DECISION DELEGATED TO DEVELOPMENT MANAGER

Application No: H16-0998-19 **Applicant:** Mr G Baxter

Proposal: Erection of detached bungalow - Plot 1 - approved under H16-0266-19 - Amendments to position and sizes of windows and doors

Location: Laburnum Lodge 40 Spalding Common Spalding

Elevation 03 – Rear
1 : 100

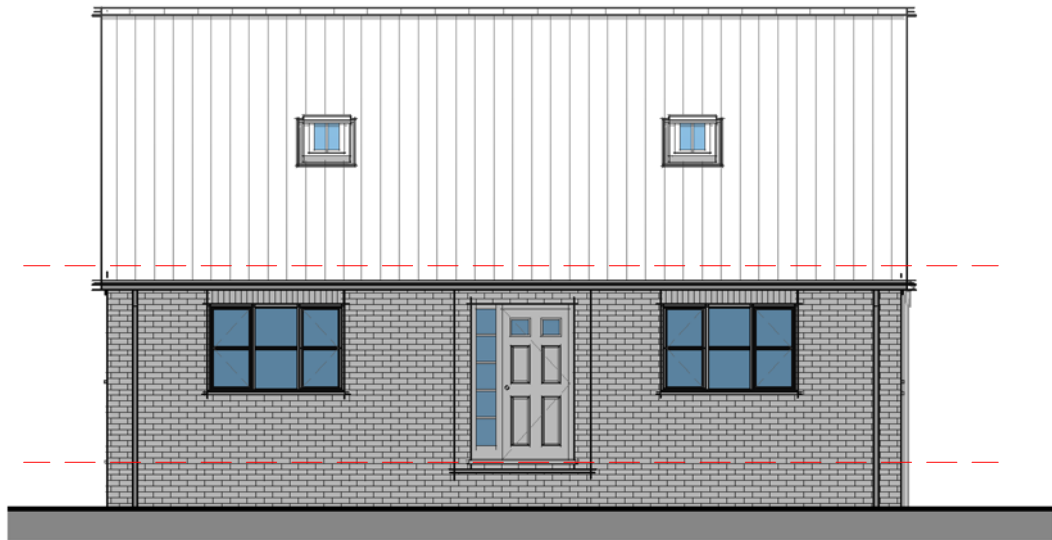
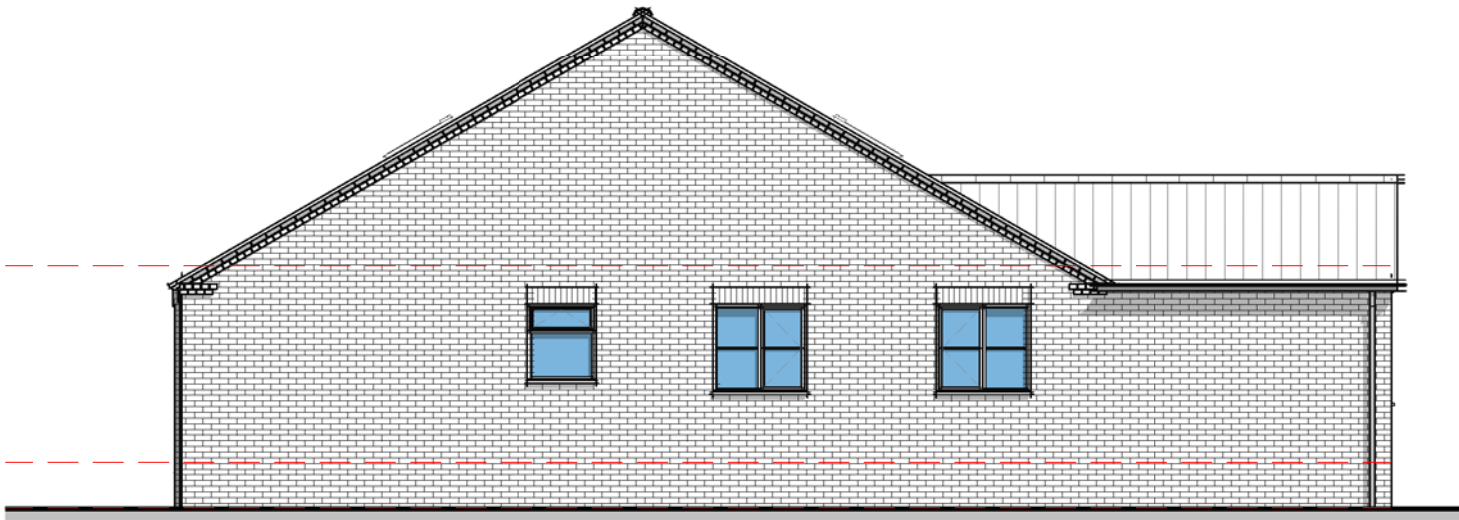
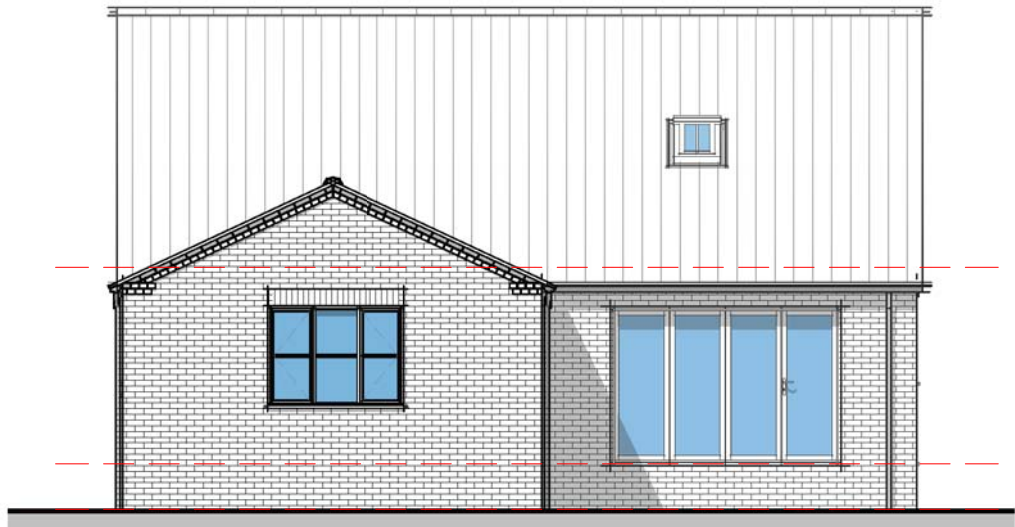
A window serving the kitchen / dining area has been moved from the dining area to above the kitchen sink, with a rear facing window placed at the dining area.

Plot 1 Floor Layout

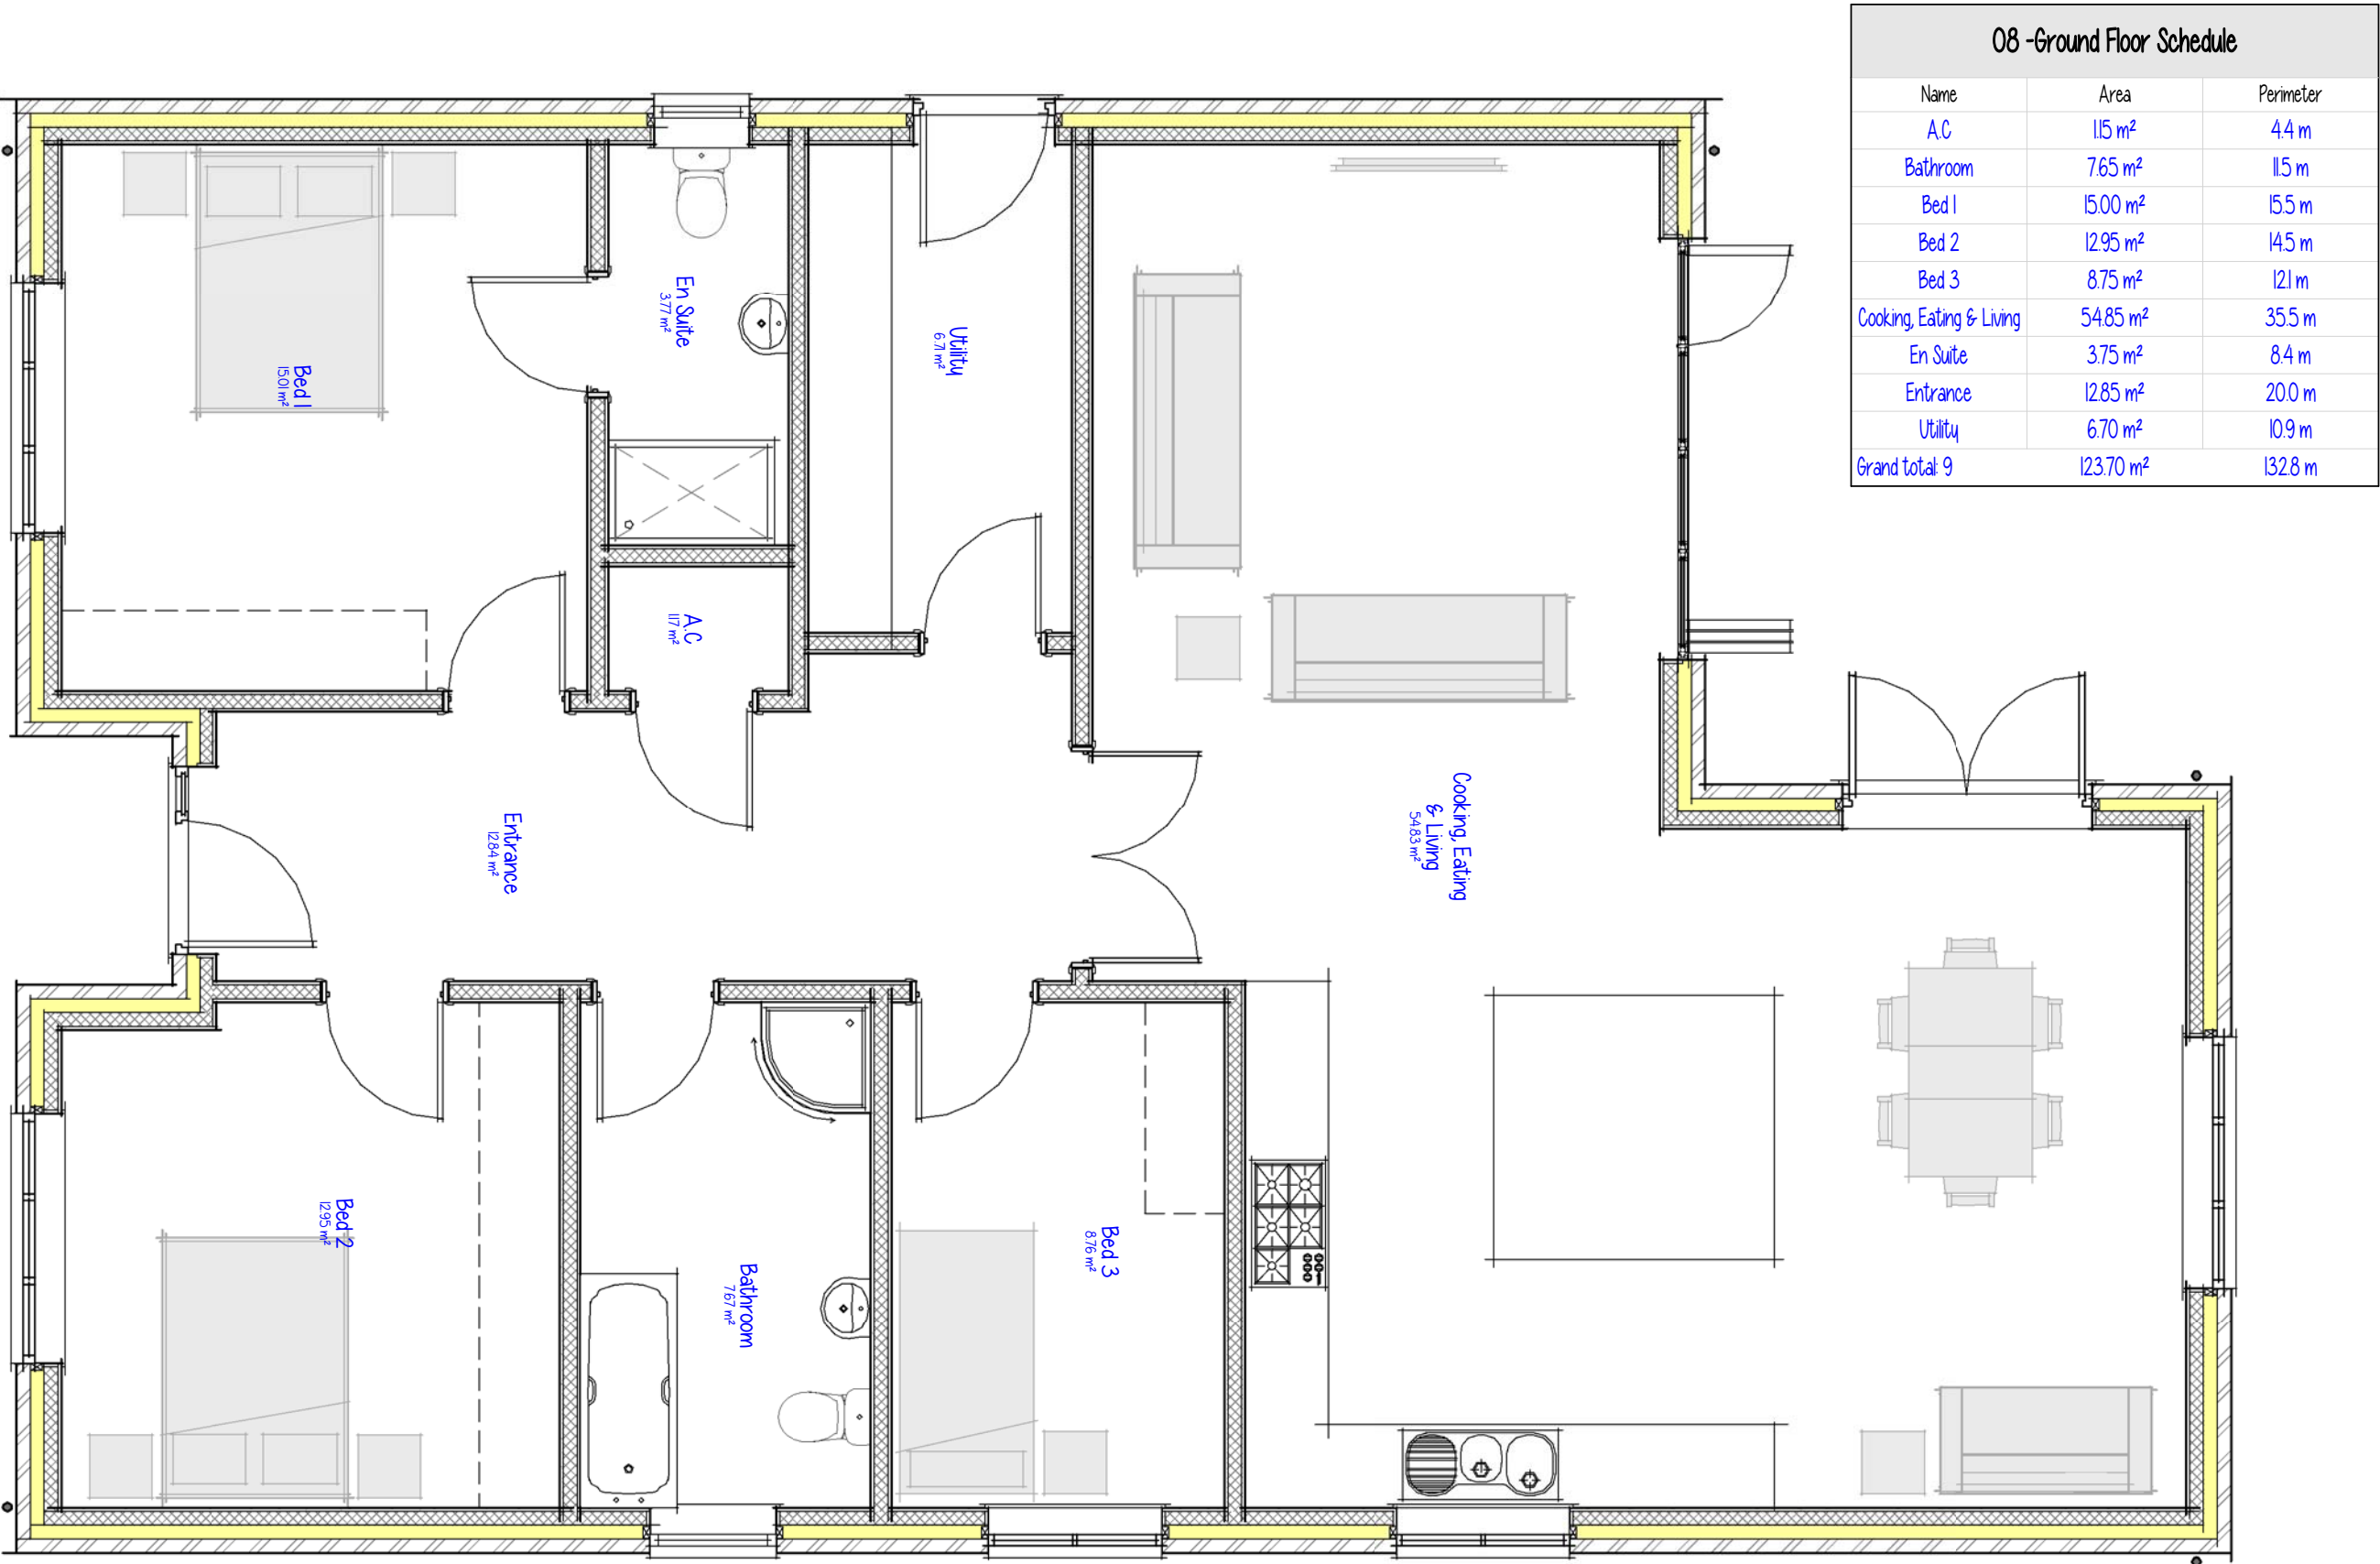
The proposed fenestration amendments do not affect the character of the dwelling or the amenity of Plot 2 to the south of the site.
